COUNTY OF HARNETT RESIDENTIAL LAND USE APPLICATION

PROPERTY LOCATION: Subdivision: Persimmon Hill Lot #: 83 Lot Size: .11 AC

Re: Status of Improvement Permit Application #08-5-19243 - Lt 83

Harnett County Department of Public Health Site Sketch

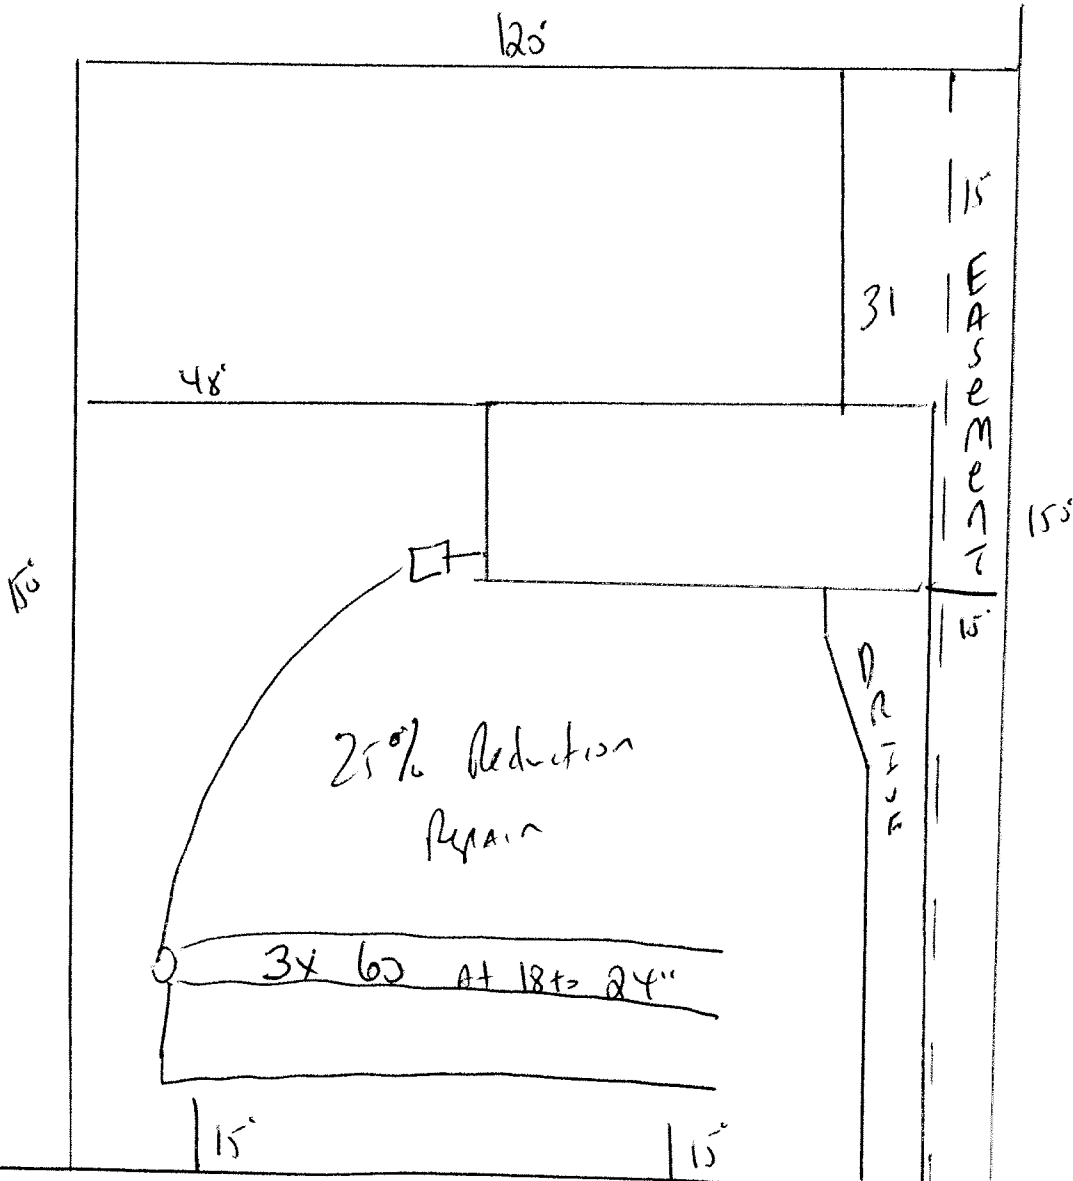
6. Other – Move house as shown on attached sheet. You have 2 options, submit new plot plan to Central Permitting.
